Roussell Road Warehouse and Distribution Centre (SSD-41807966)

Please find enclosed a response to Blacktown Council's informal comments (emailed 24.05.23) on the draft RTS package as they relate to biodiversity.

Figure 2: Extent of works for vegetation management plan

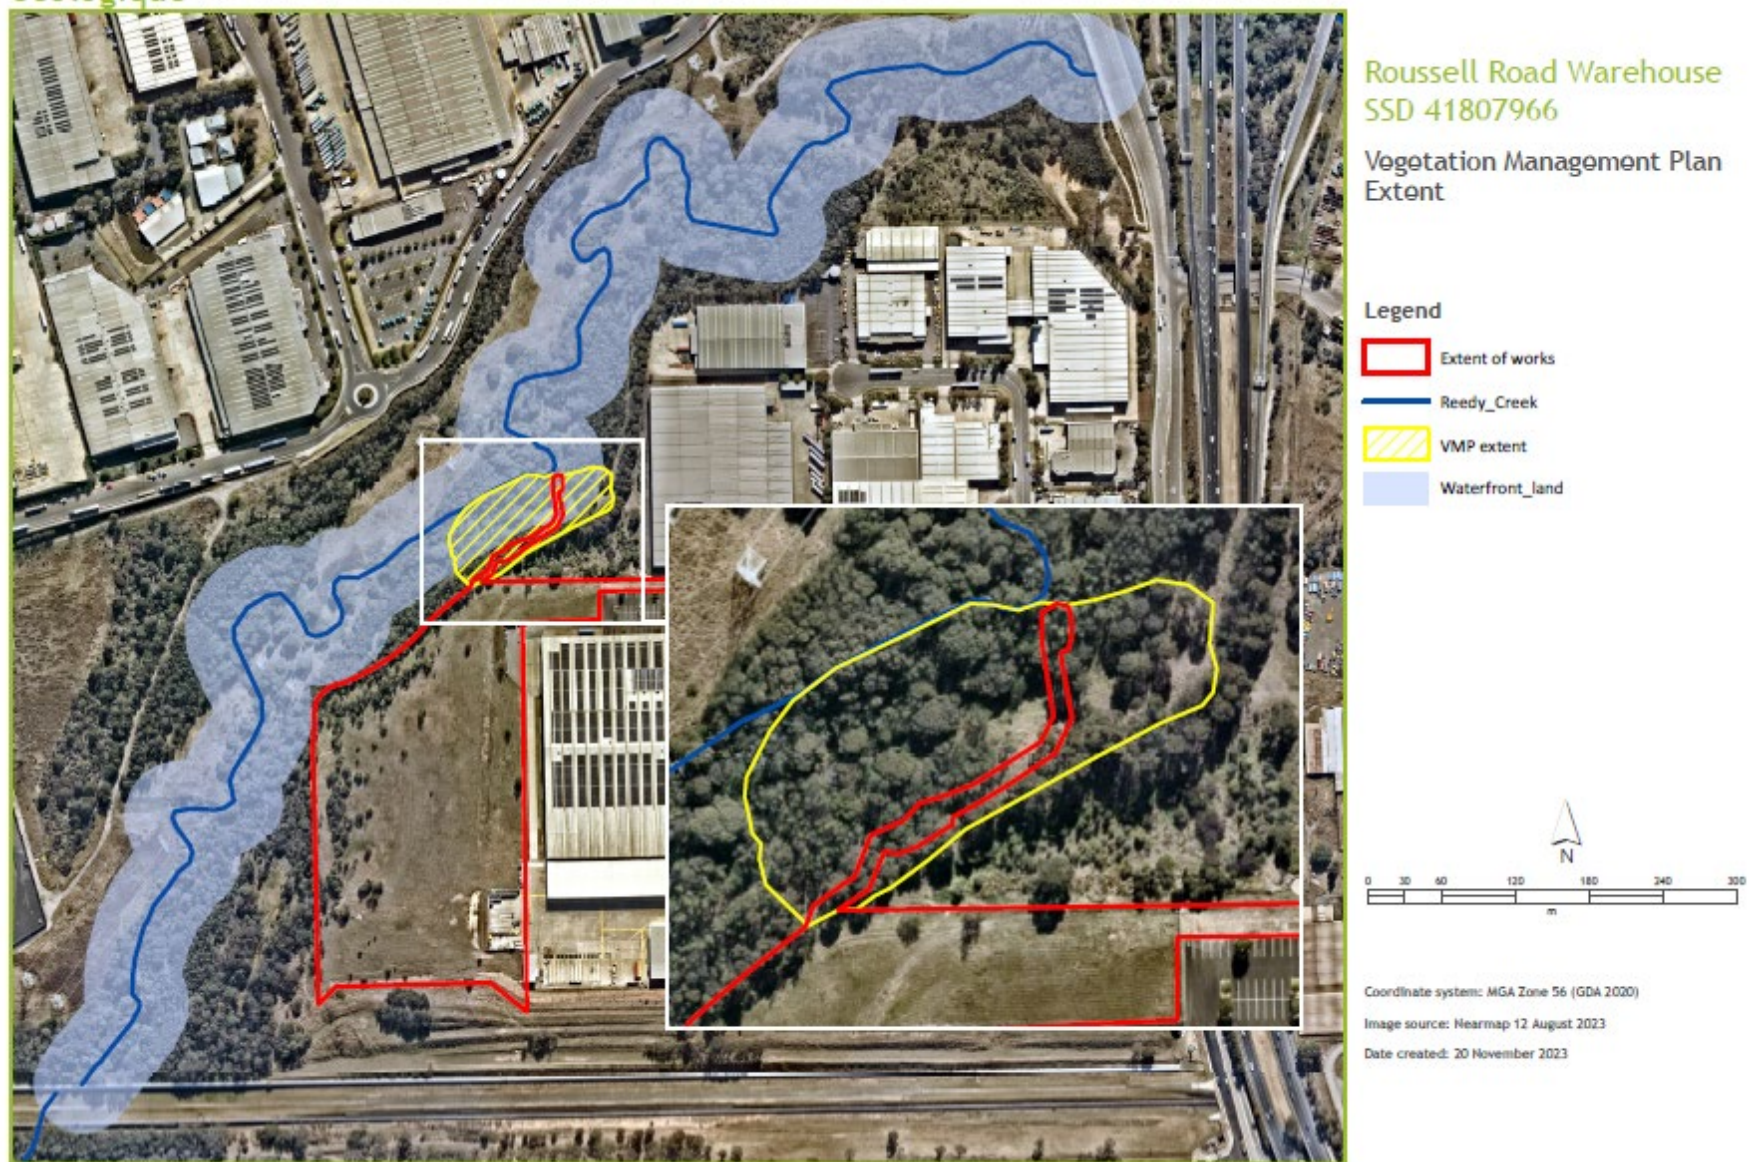
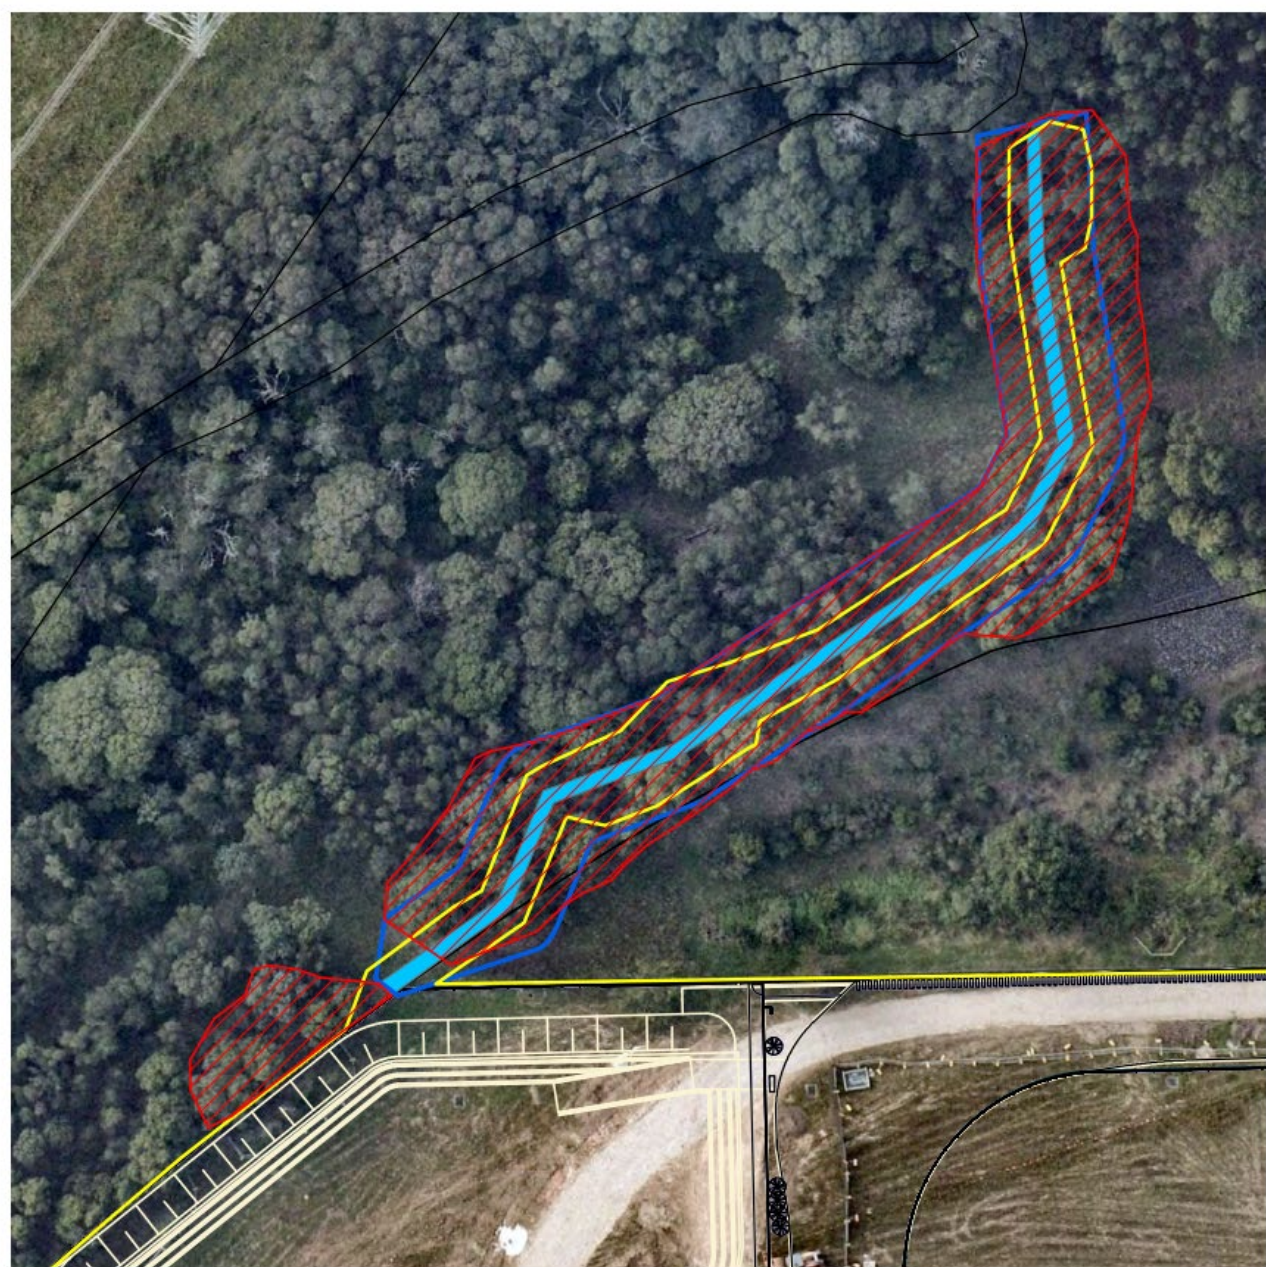
Comment	Response
Increasing the separation of the proposal from the riparian corridor would also enable avoidance of impacts to the threatened ecological community PCT 1800, particularly that located within the riparian buffer for Reedy Creek. It would help to reduce direct and indirect impacts on this TEC and associated habitat for native and threatened species. It would reduce light spill to nocturnal bats and birds that could potentially use the adjacent vegetation for breeding, roosting and/or foraging. The subject land provides connections to vegetated areas to the south, east and north of the subject land, including eastwards and northwards to Eastern Creek. The riparian corridor is thus important to fauna movements as well.	The protection of the riparian corridor was considered in the planning and definition boundaries adopted (as shown in Figure 2). This has resulted in a much wider vegetated riparian zone than required under the WM Act. PCT 1800 within the Reedy Creek riparian zone has been substantially increased in extent (albeit this PCT did not exist at the time and the VMP reinstated river-flat eucalypt forest) in poor condition has encroached from established within the subject site due to: • A long delay in developing the western section of the lot; and • A lack of maintenance between clearing and earthworks (including fill) to establish a levelly formed pad for industrial development, as shown in aerial photograph below: The aerial photograph shows a large, rectangular, light-colored industrial pad situated next to a dark, vegetated riparian corridor. The pad appears to be a cleared area with some structures or equipment visible. The surrounding area includes more vegetation and some other industrial buildings in the distance. Above: finished industrial pad (2009) The development will increase light spill above that which currently exists, however this was always going to be an outcome of the Precinct's planning and provisions made for the riparian corridor. The potential indirect impact of light spill was accepted by the consent authority to not represent a significant impact. This due to the surrounding arterial and local road networks and industrial development (see appended location photographs). The development does not directly impact on the riparian corridor, which has been substantially improved through the implementation of the Precinct's VMP. The eastern riparian zone adjacent to the development provides a minimum width of 45m and maximum width of 150m, which is substantially above and beyond current approval conditions (see Figure 3).
